# CITY OF ALBUQUERQUE

December 8, 2023

**Re: Home 2 Suites Hotel**  
**3021 Flightway Ave SE**  
**Request for Certificate of Occupancy- 30 Day Temp**  
**Transportation Development Final Inspection**  
Engineer's Stamp dated 10-26-21 (M15D047)  
Certification dated 12-5-23

BIKE RAIL

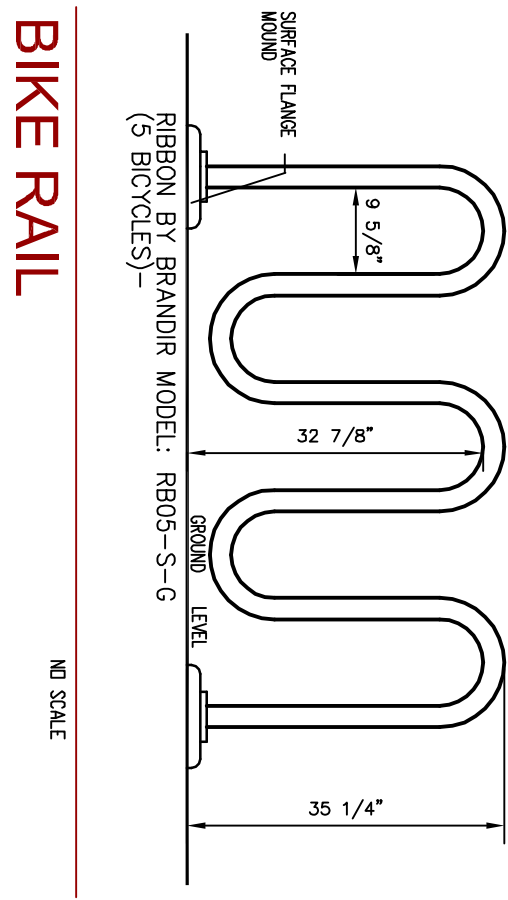
1. The 6' pedestrian pathway to University Blvd is not wide enough. At three locations between the parking lot and the ramp, it was  $\leq 46"$  wide between curbs and one location it was 41".
2. Provide five bicycle parking spaces. Currently, there is one wave-style rack, which offers the possibility of providing two bicycle spaces.
3. The approved plan specifies 5 motorcycle parking spaces; however, the IDO only requires 4. Only two were observed on the east side of the building. Provide 4 motorcycle parking spaces.
4. The ramp north of the accessible parking aisle had an average longitudinal slope of 11.6%; which is steeper than the maximum of 8.3%. The ramp should be replaced with a ramp with an acceptable longitudinal slope.
5. A "No Parking" pavement marking is required at the back end of the accessible parking aisles. See image on next page.
